5 April 2019
Our Ref SU7340
Your Ref: SDD8699

**Redevelopment of Greenwich Hospital (Concept Proposal) at 97-115 River Road
Greenwich (SSD8699)**

I refer to your Notice of Exhibition dated 11 February 2019 and accompanying two volumes of the Environmental Impact Statement (EIS) in relation to a Development Application for the Redevelopment of Greenwich Hospital (Concept Proposal) (SSD8699).

12:00pm

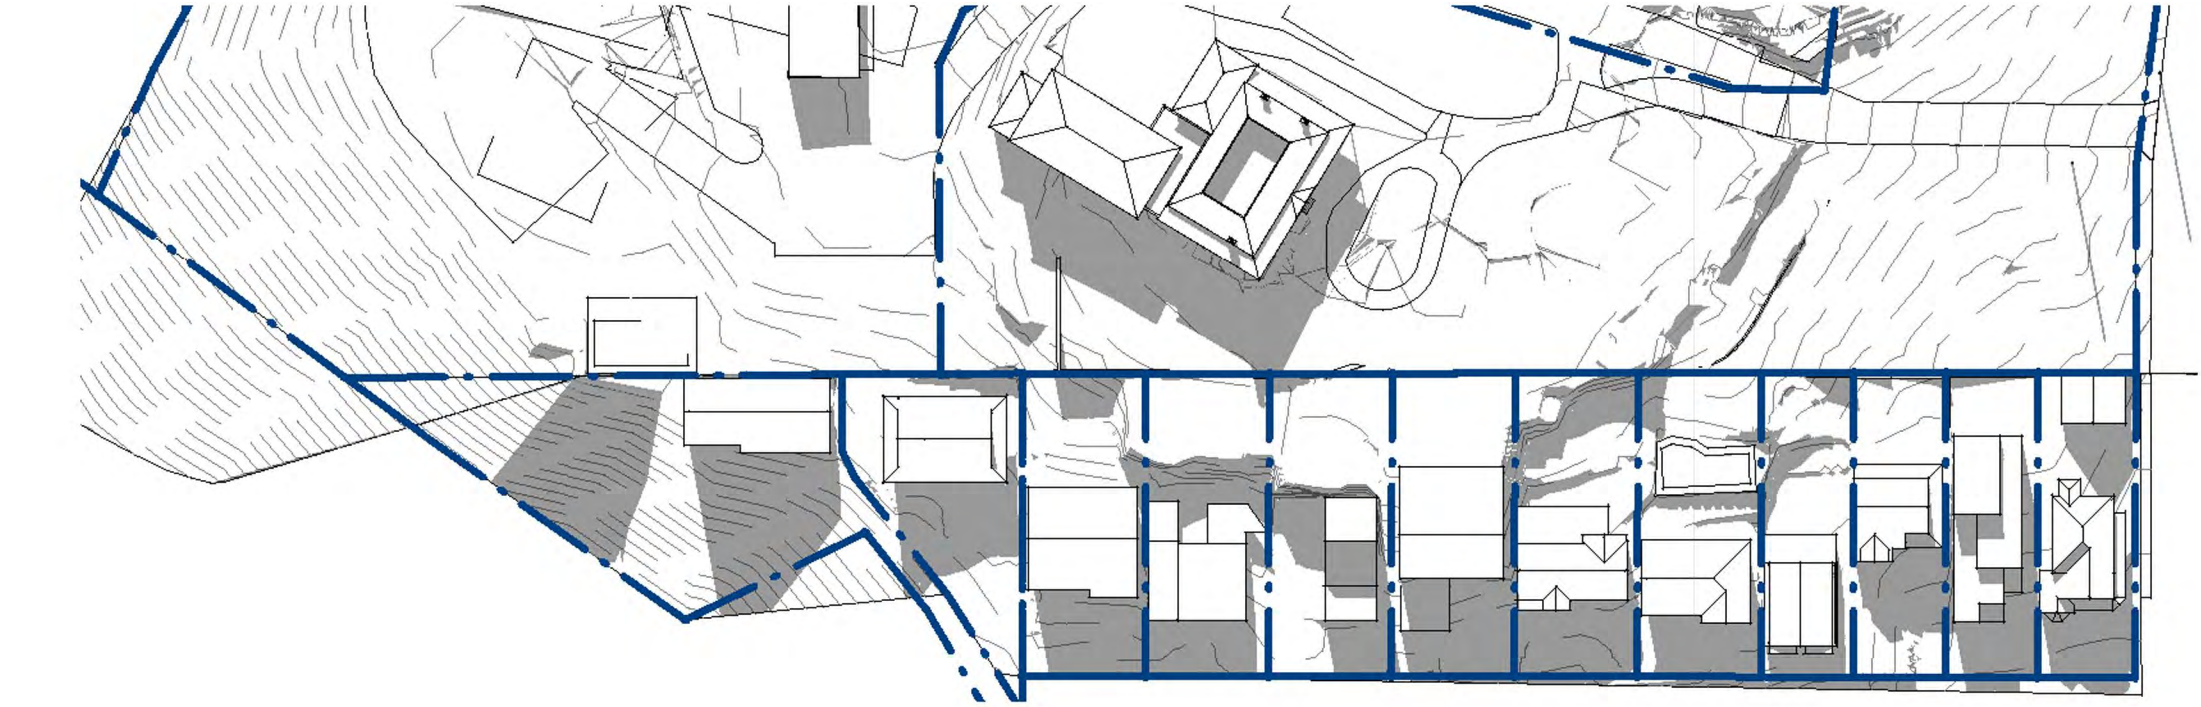
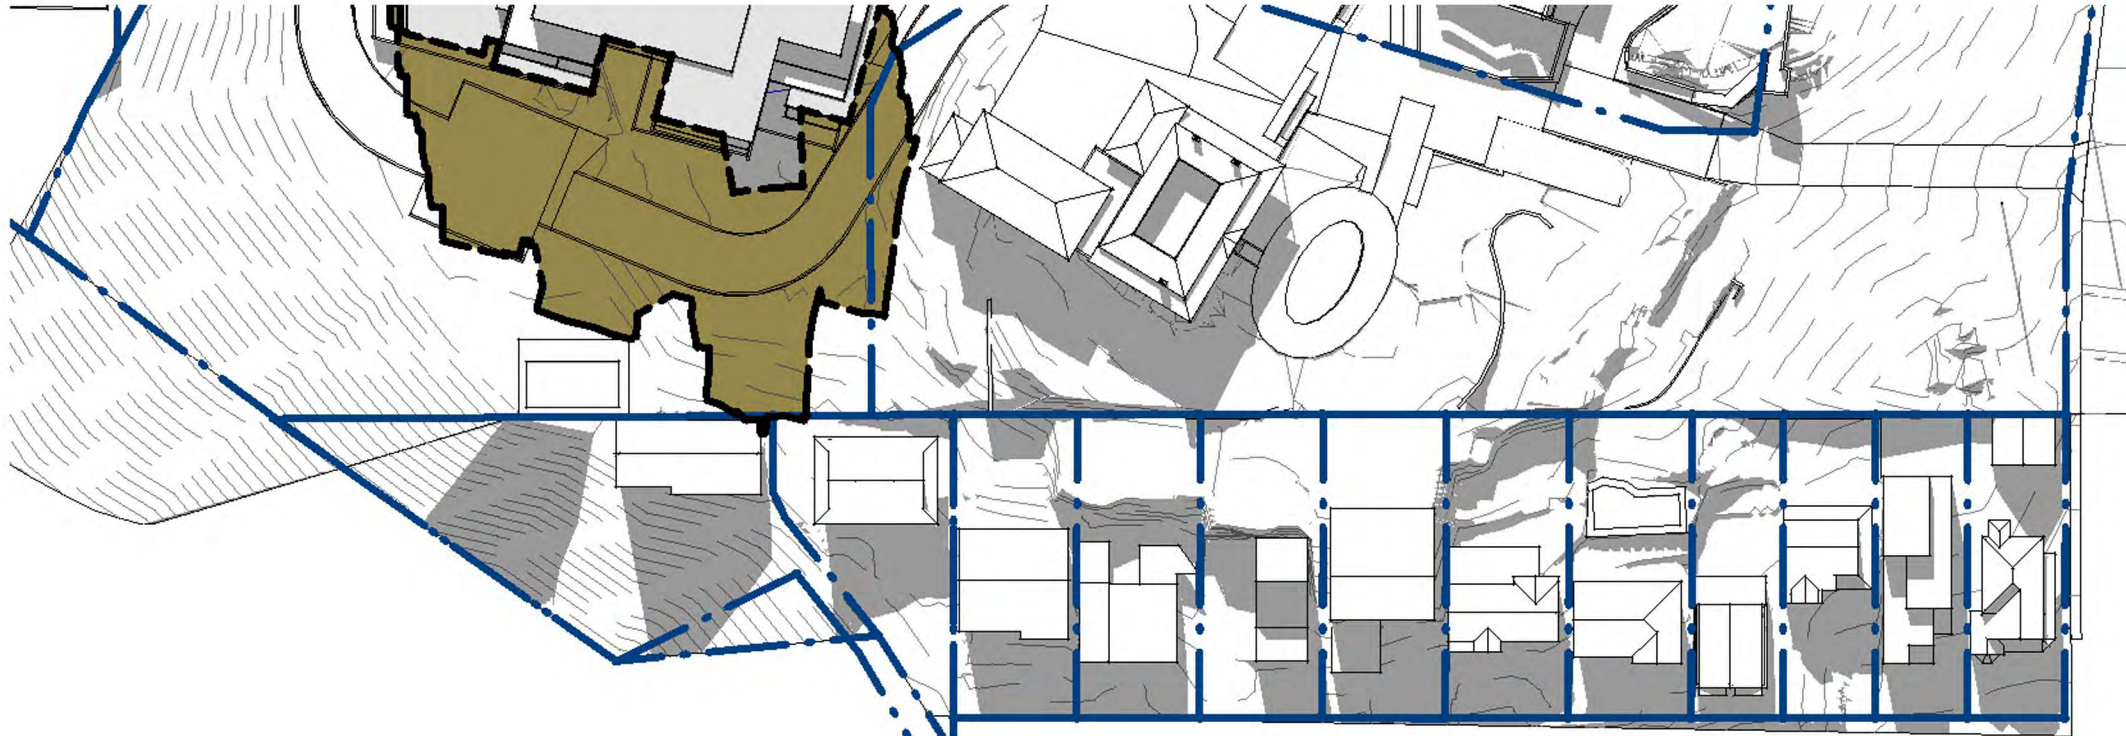
The proposal indicates an increase in shadows south west of the site at 9.00am during mid-winter. The DCP recommends new buildings and structures to be designed and orientated to ensure reasonable sun access is maintained to adjoining bushland throughout the year.
